A38 Derby Junctions
TR010022
8.15 Statement of Common Ground with
McDonald's

Statement of Common Ground
McDonald's

Version	Date	Status of Version
Draft	10 February 2020	Deadline 5 Submission

DELIVERY TRACKS

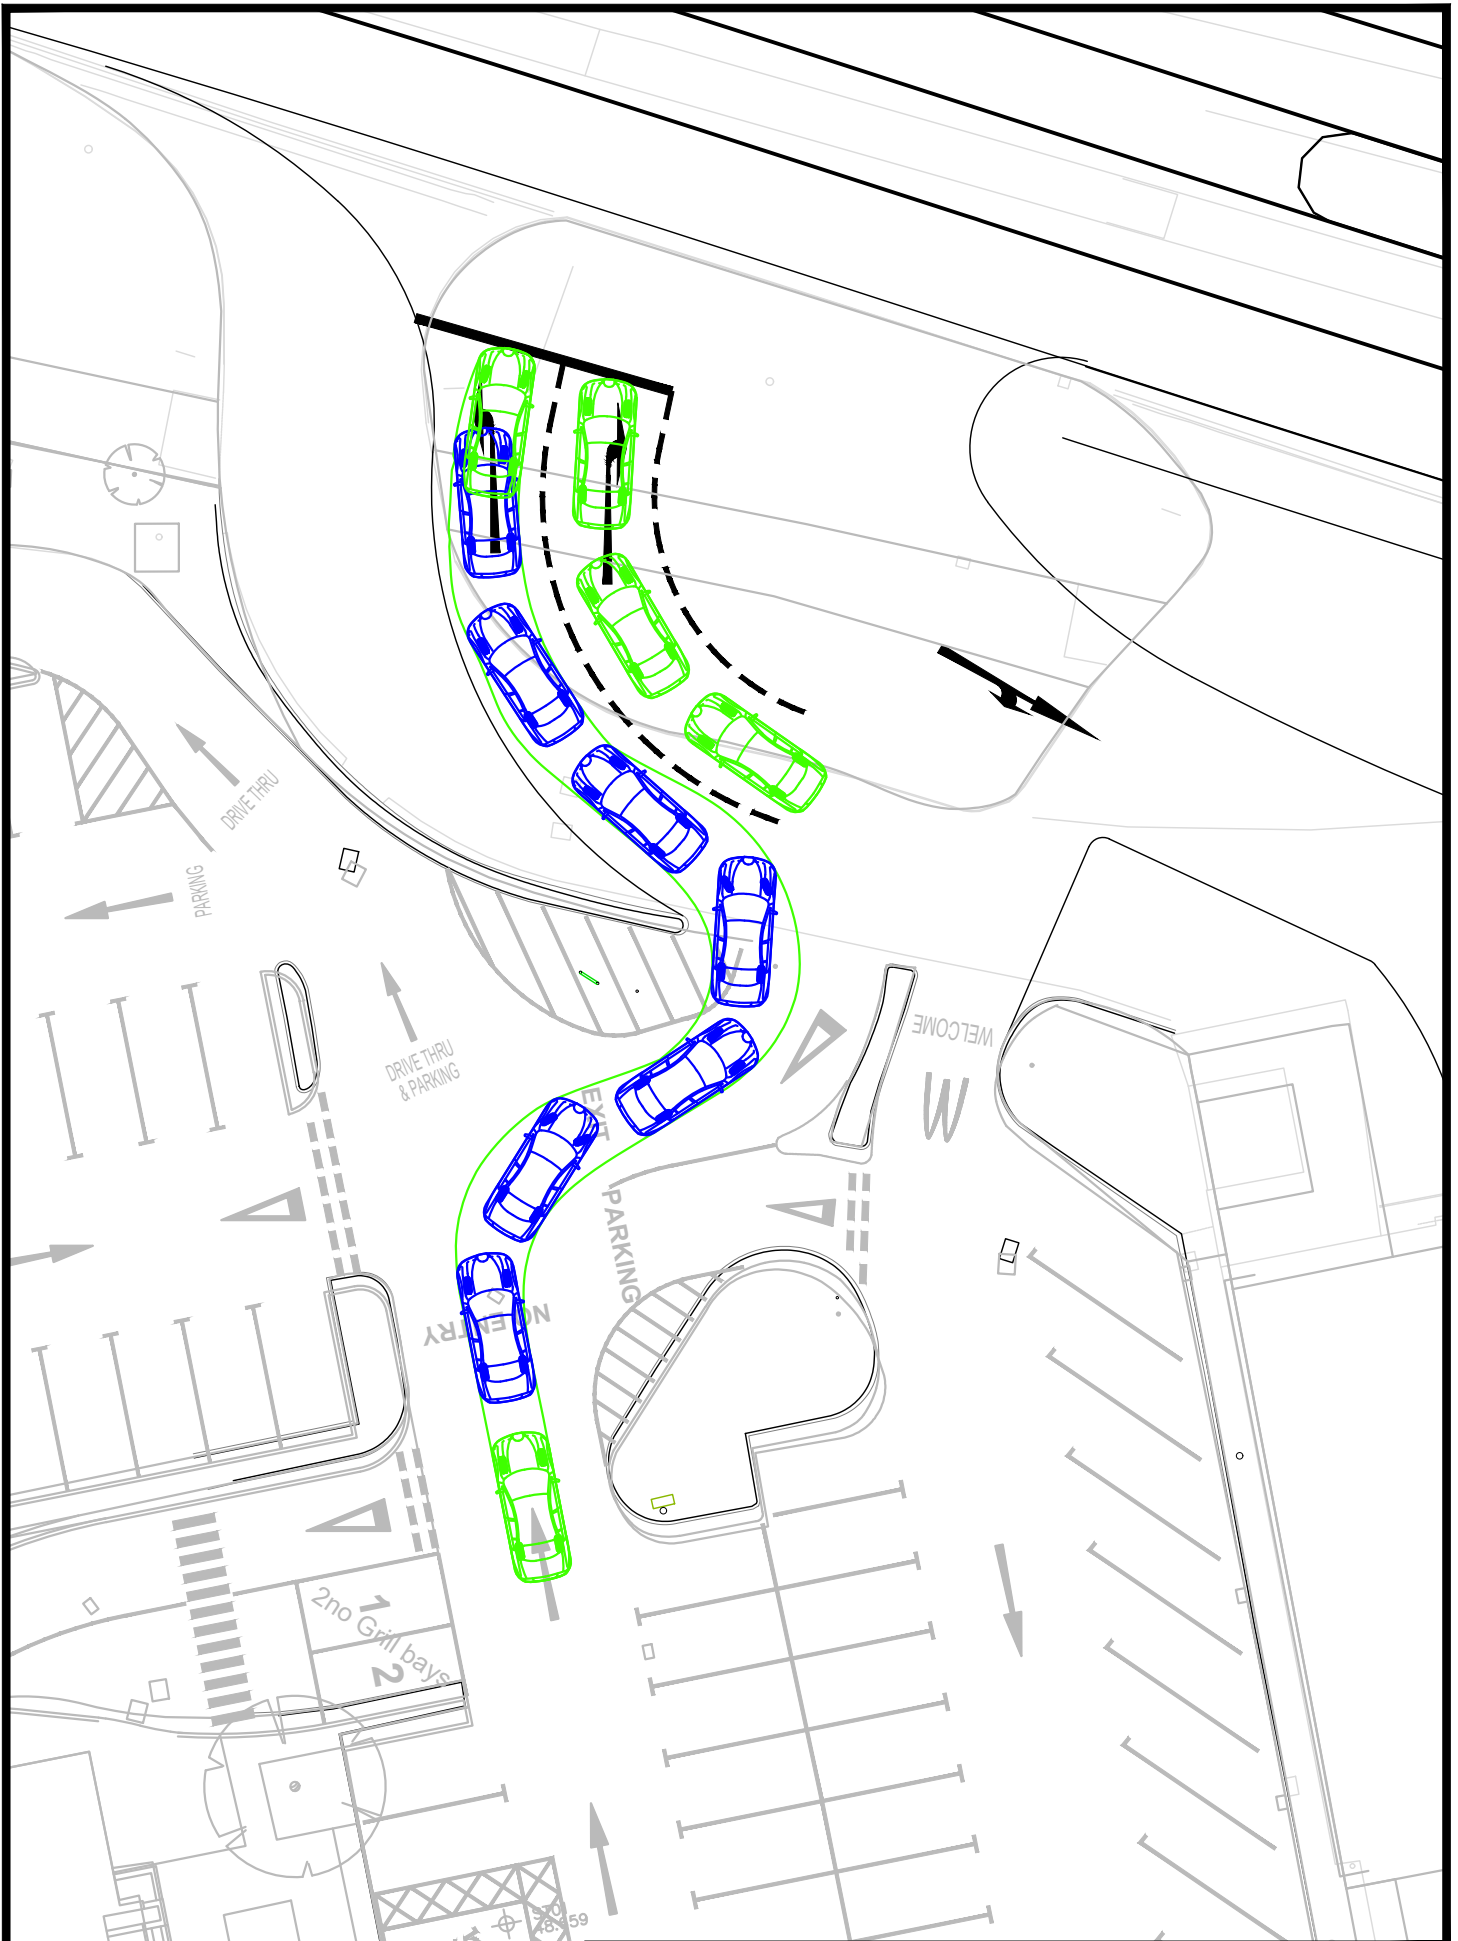
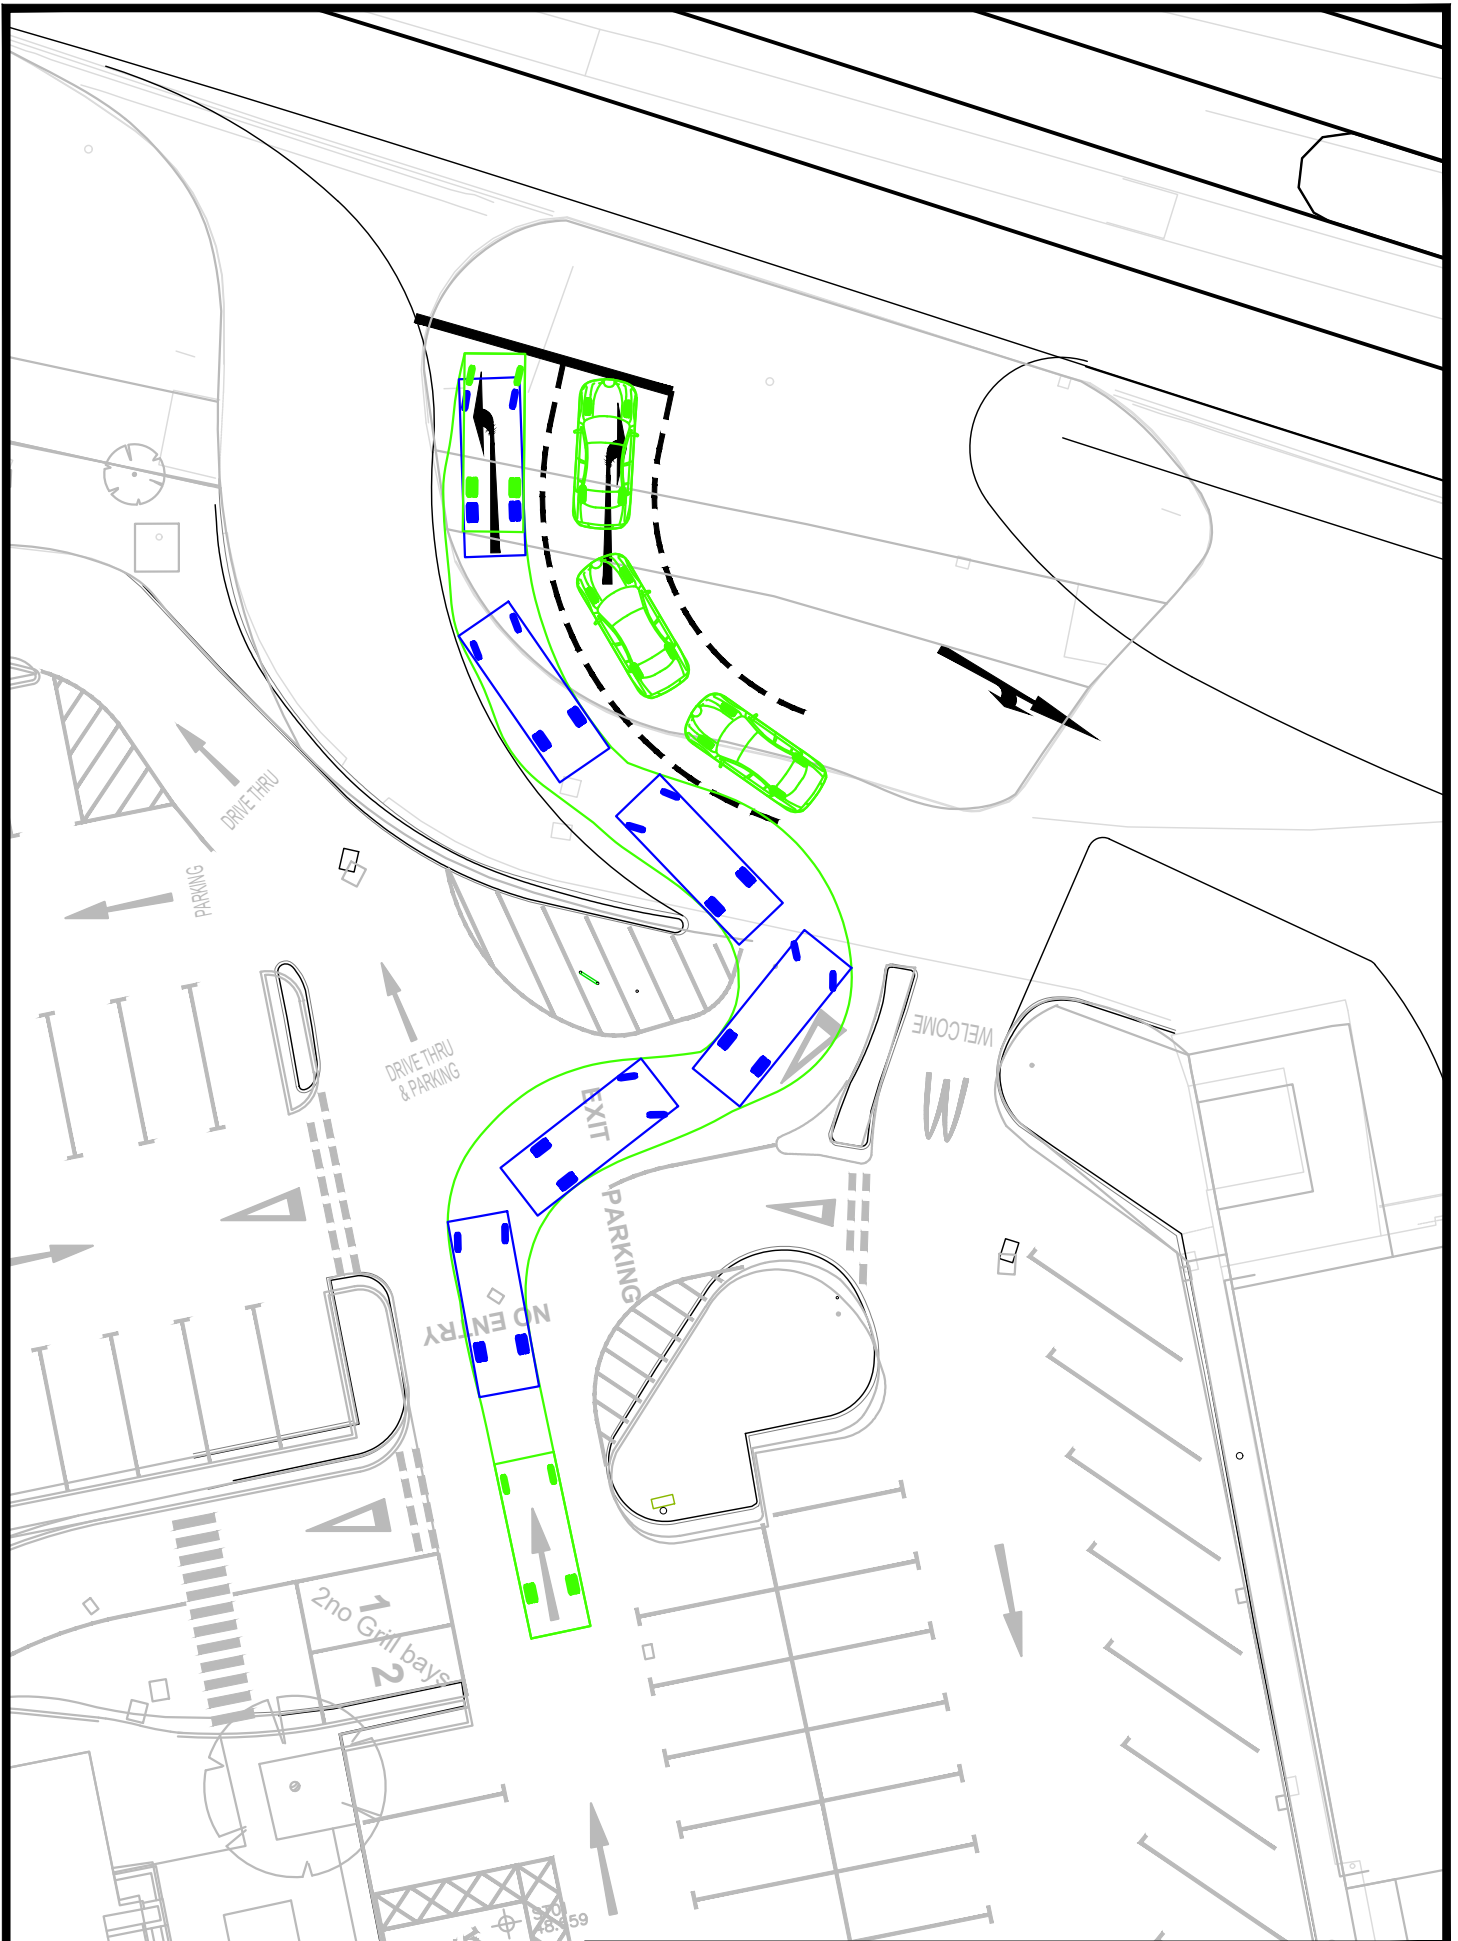
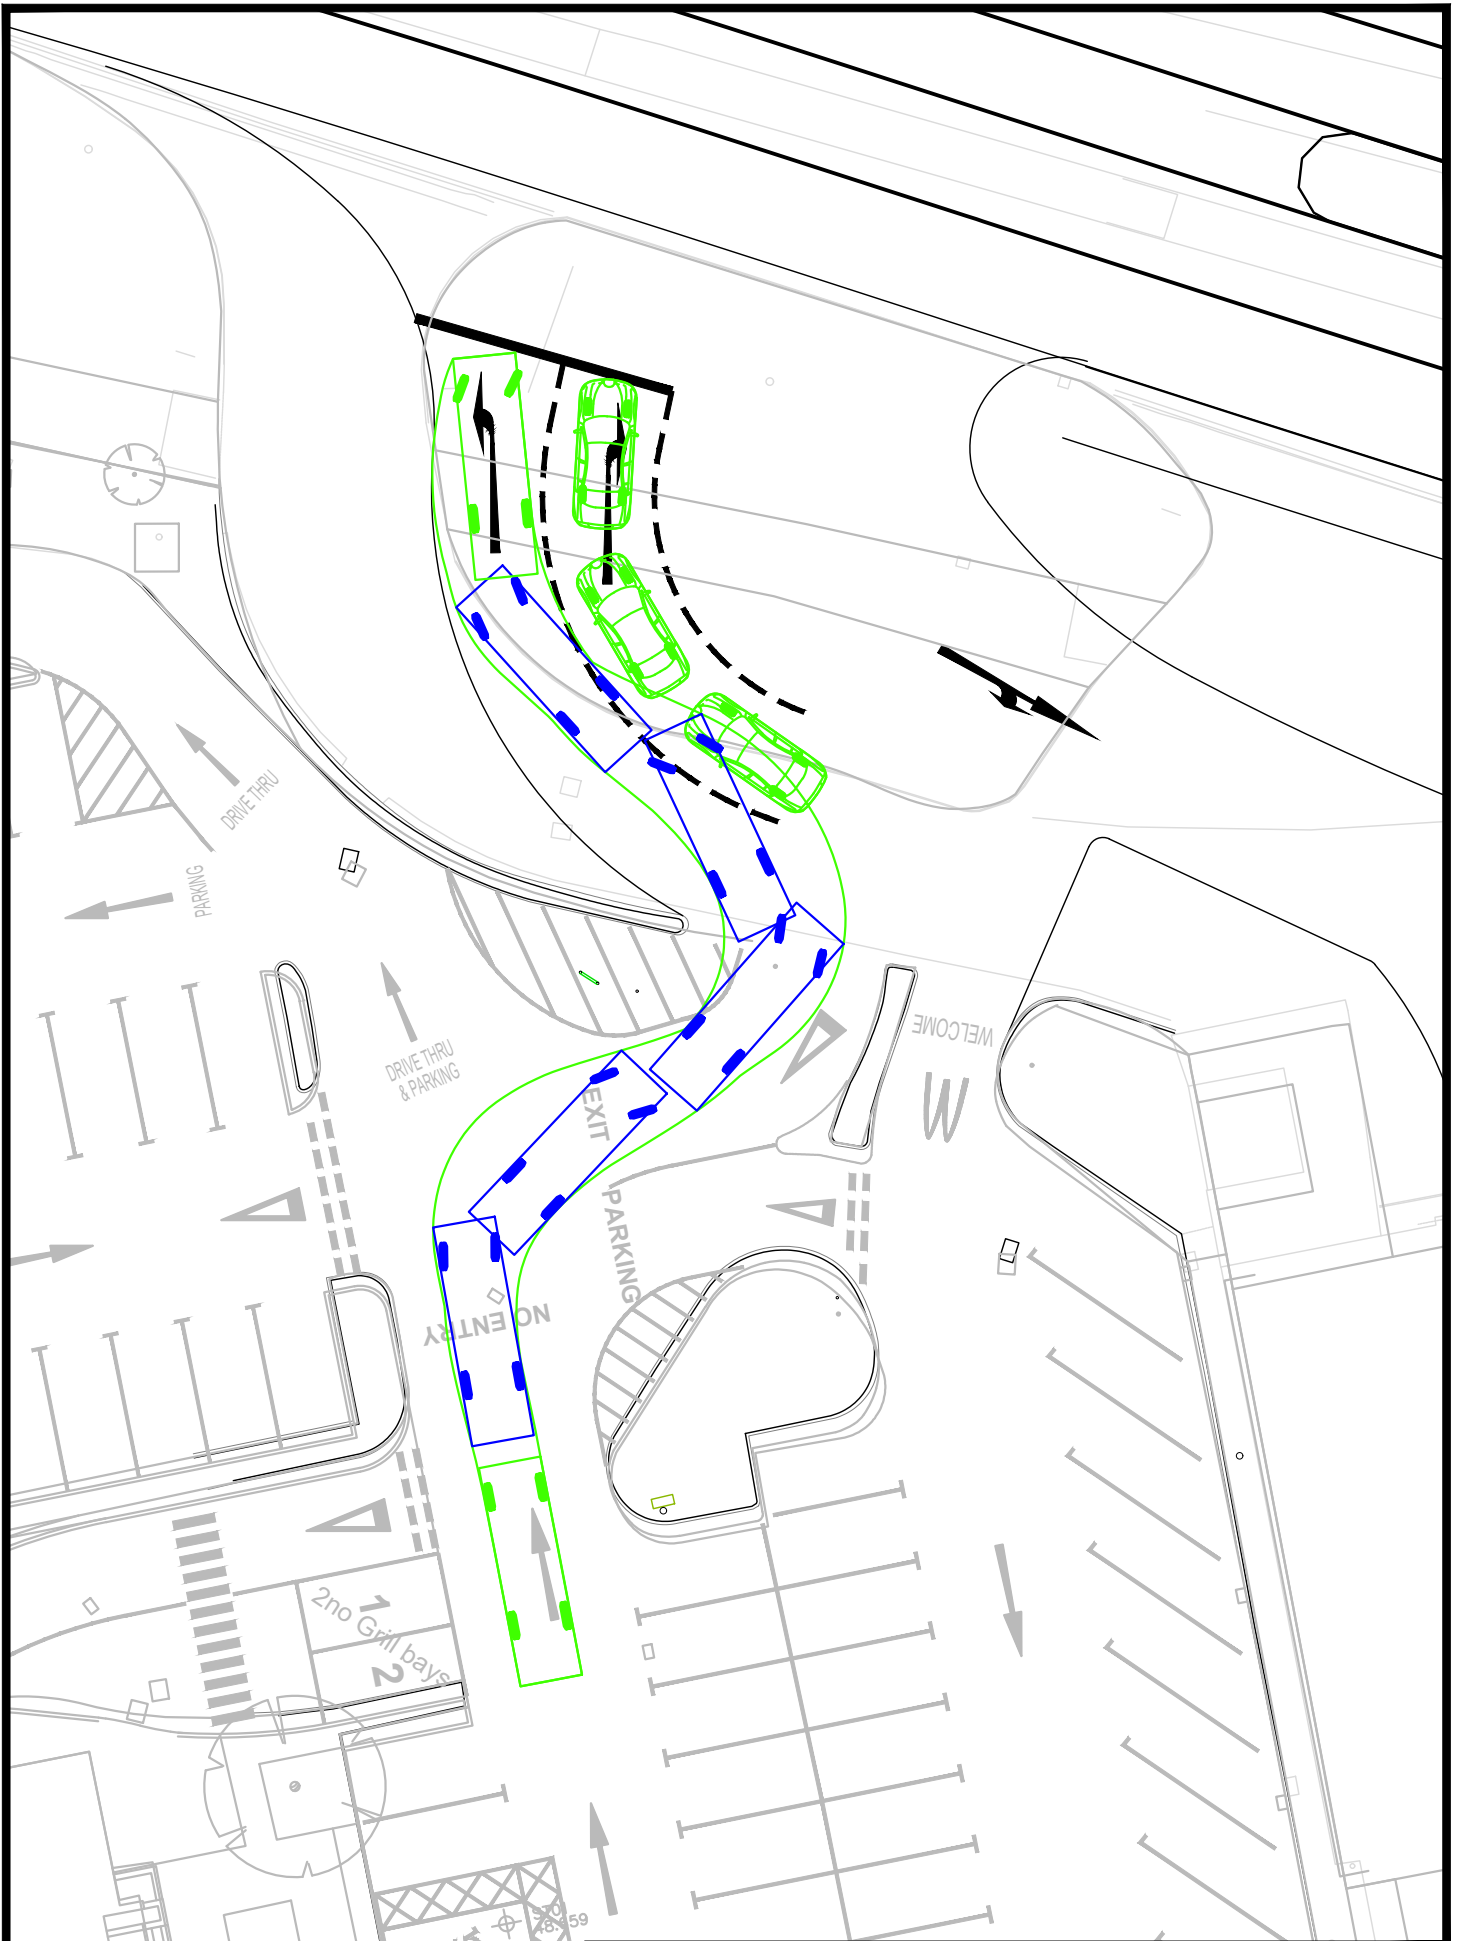
Issues Reference (see Appendix A)	Document	Paragraph Ref	Sub-section	Comment	Highways England Response	Status
Issue ref: I.1, access and potential impacts	Written Representation Comments*	Point 2	a)	<p>Currently, deliveries to the Property are received five times per week from the A38 entrance. The Works necessitate a change in delivery routes into the restaurant. The proposed route does not account for how McDonald's delivery vehicles manoeuvre around the Property or potential health and safety concerns. Delivery cages weigh hundreds of kilograms and McDonald's' car park is reinforced in the south part only. By closing the A38 entrance, delivery vehicles will no longer be able to service the Property; they are too heavy to safely cross the unreinforced north section of the Property.</p>	<p>Swept path diagrams have been provided to demonstrate that access for deliveries from the proposed new A52 access is feasible within the current car park layout (and crossing onto the Euro Garages land as they do at present).</p> <p>Highways England has advised that, during the detailed design stage, pavement surveys could be carried out to determine the strength of all parts of the car park – strengthening could be carried out as accommodation works if required.</p> <p>Highways England would welcome details of the existing car park construction (strengthened area and non-strengthened area) if available to be able to assess the load bearing capability.</p> <p>At the meeting of 15th Jan 2020, McDonald's noted that they have committed to taking core samples in their car park – the resulting information</p>	Under discussion
